Your Ref: OWPC24576
Our Ref: BN/75/19/PL 29-08-2019
Please ask for:
Maria Tomalova

1 No. dwelling & associated works.
Land adjacent to Cherry Trees Lake Lane Barnham

Thank you for your internet representation made on 10th October 2019 which has been recorded as '**an objection**' with the comments as follows:

SITE PLAN  
1-200.

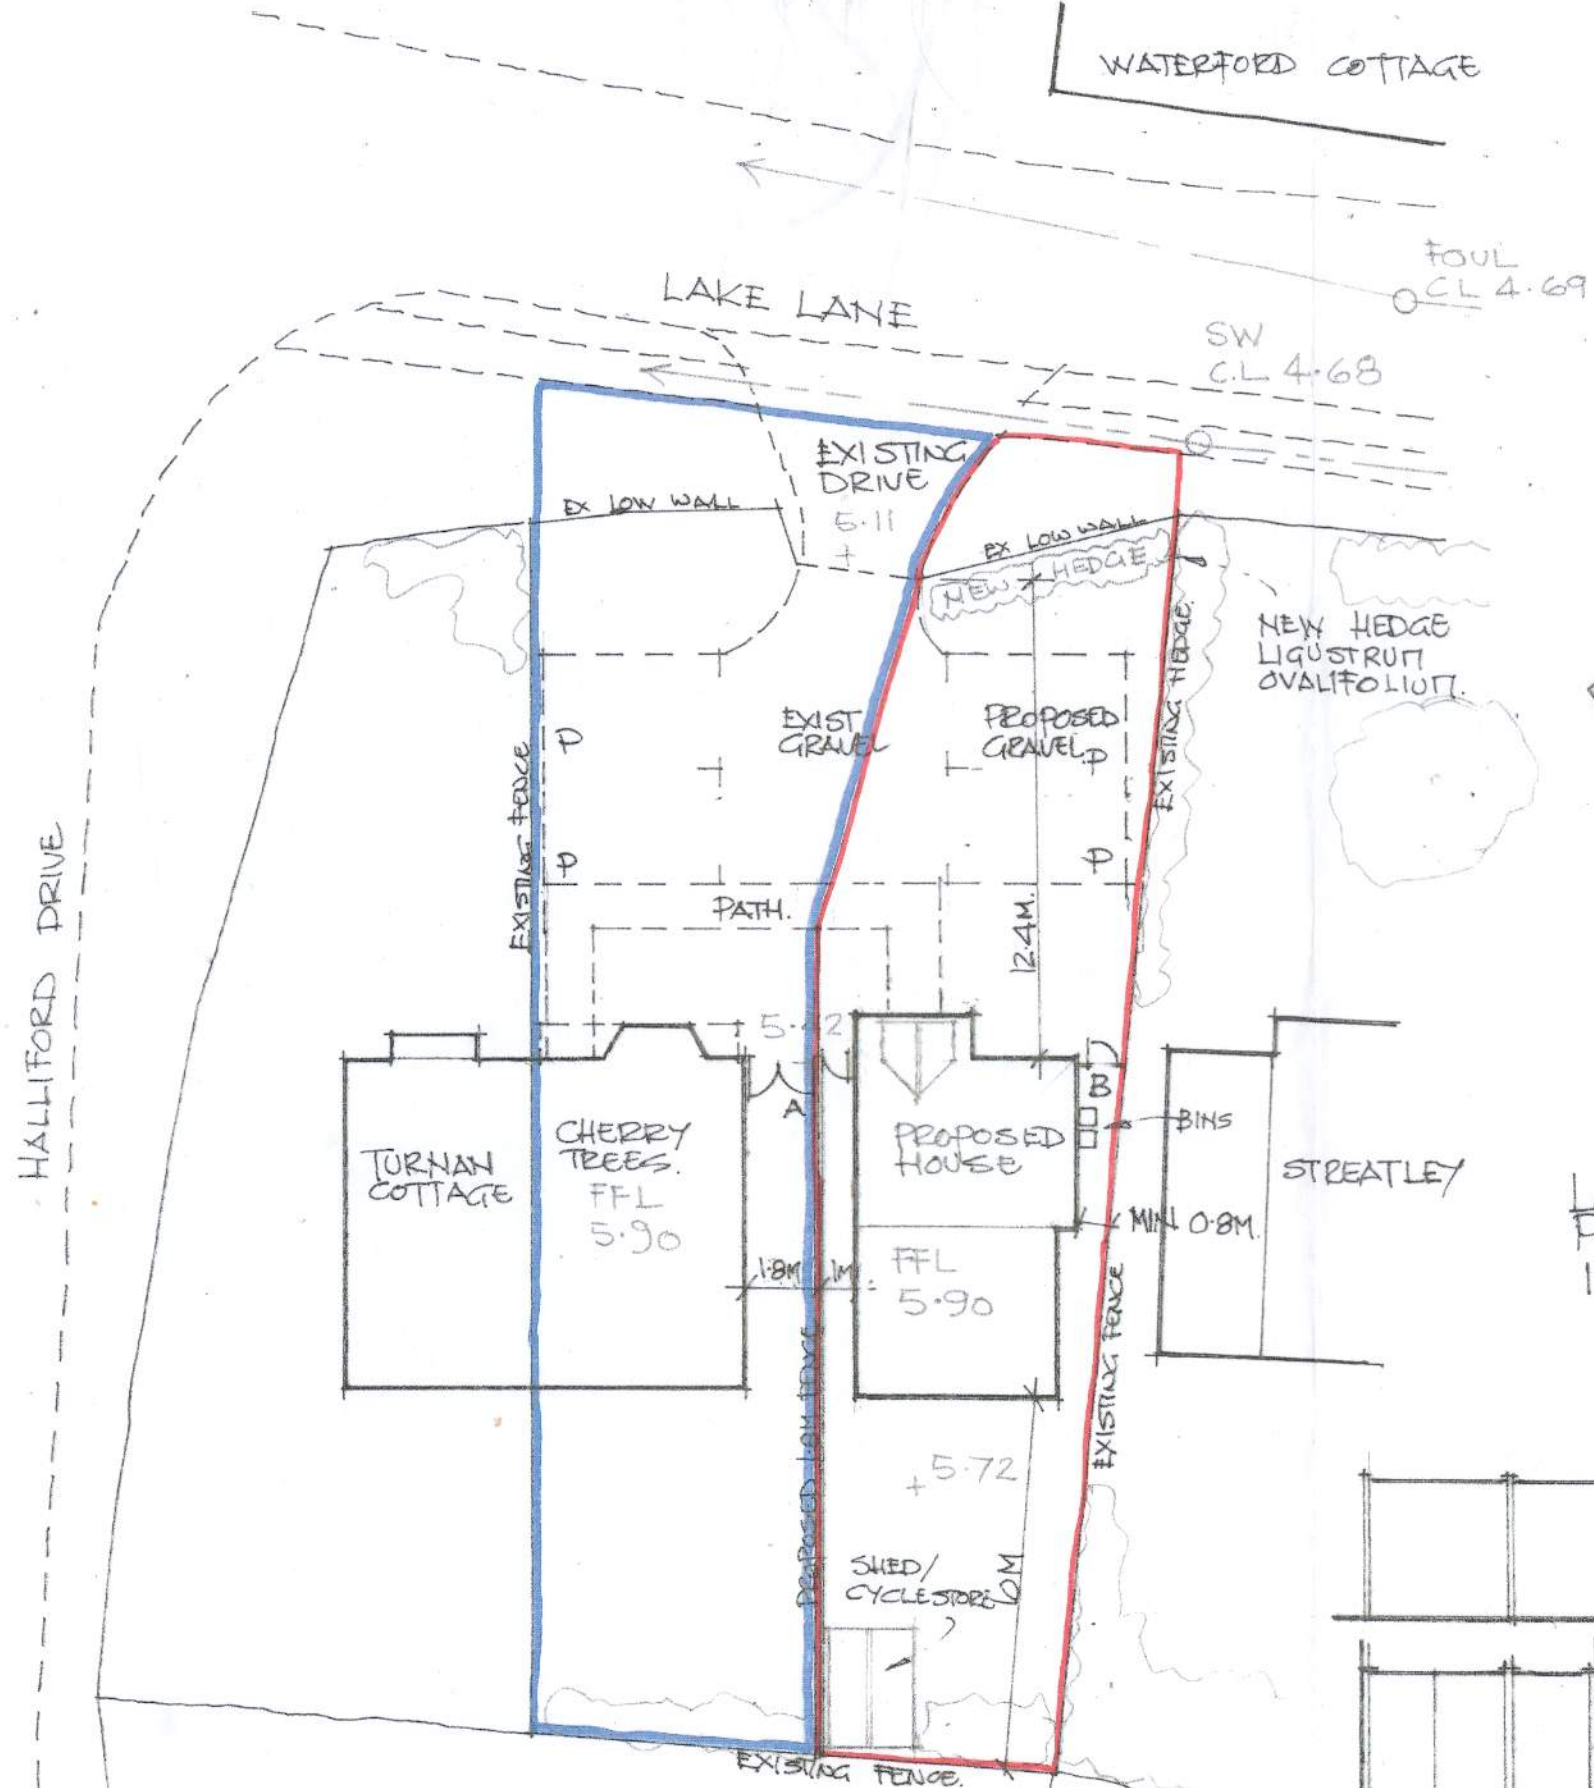
4 The statement mentions a 10m deep garden to the East. This would be directly behind our property. However the plan appears to say the garden is only 6m. Making a measurement using the scale of the front garden being 12.4m then the drawing would indicate that the back garden will be around 9m at the deepest point. Can it be confirmed that the proposed property will be 10m away from our adjoining fence as in the published statement.

PLANS
ELEVATIONS
STREET SCENE
JULY 2019
DRAWING 2.
SCALES AS SHOWN (A3)

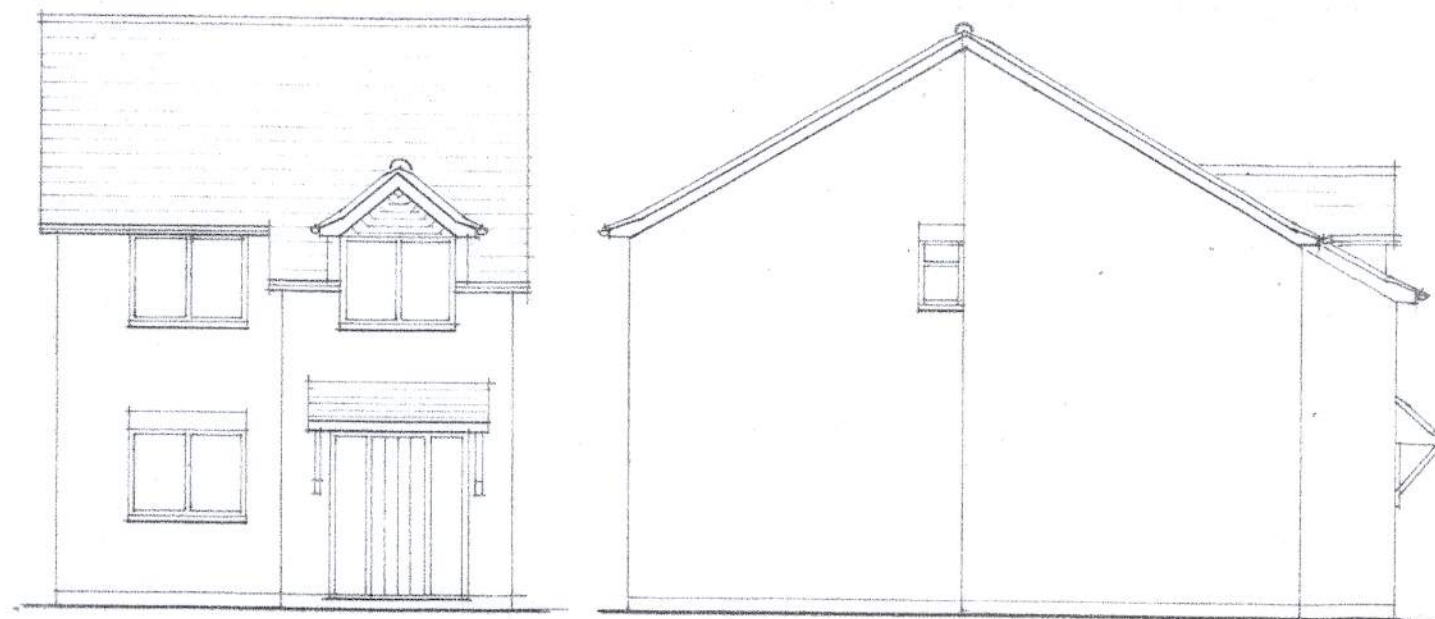
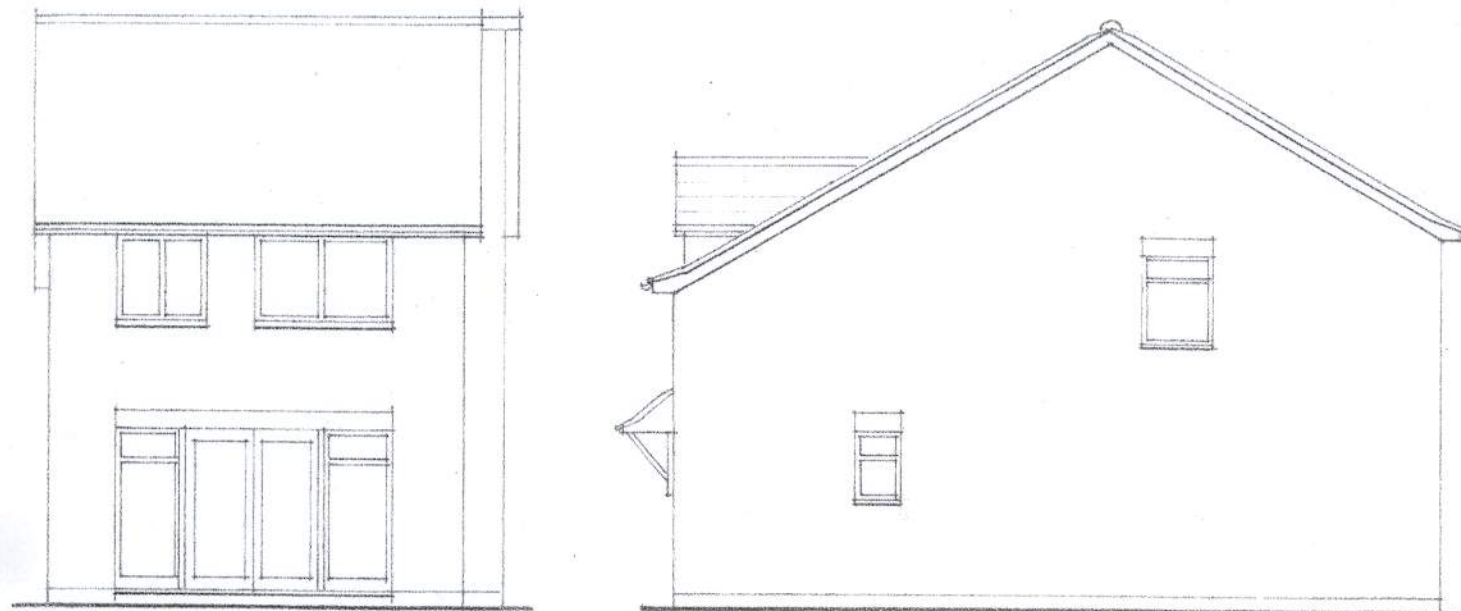
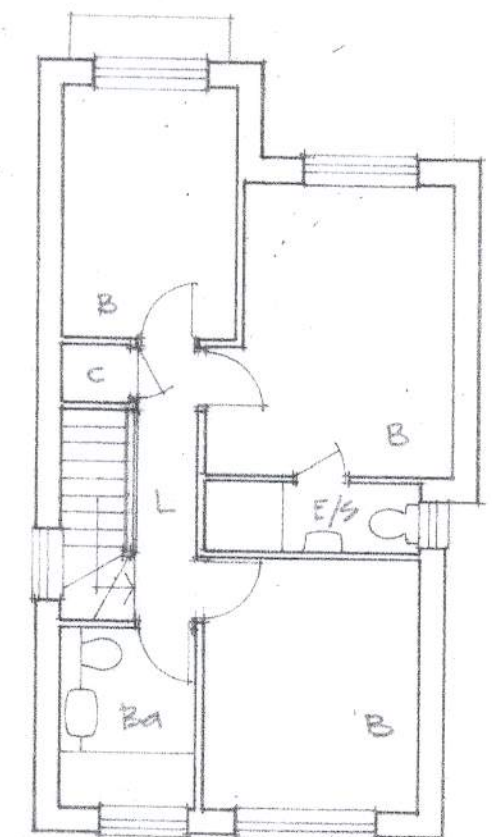
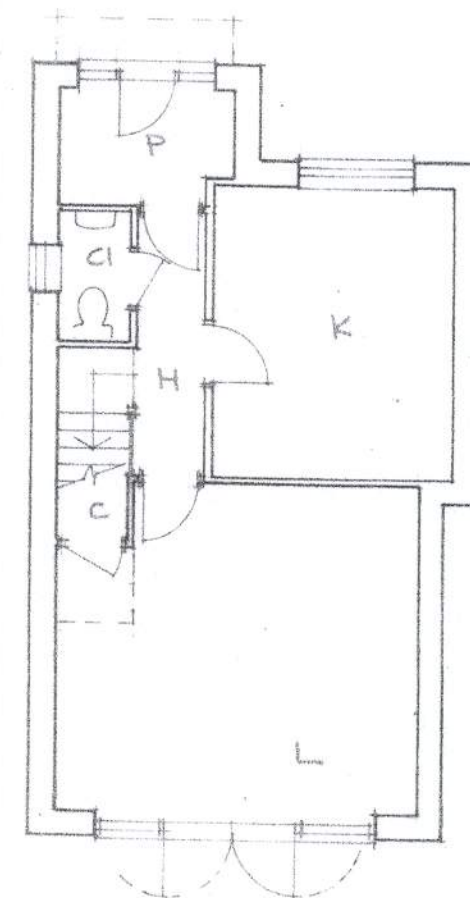
5 The statement says the scale of the building is designed to ensure that the adjacent properties are not affected. This is not the case as the proposed upstairs windows will directly overlook our garden, bathroom, shower-room, conservatory and kitchen. This will lead to overlooking and loss of privacy at very close proximity.
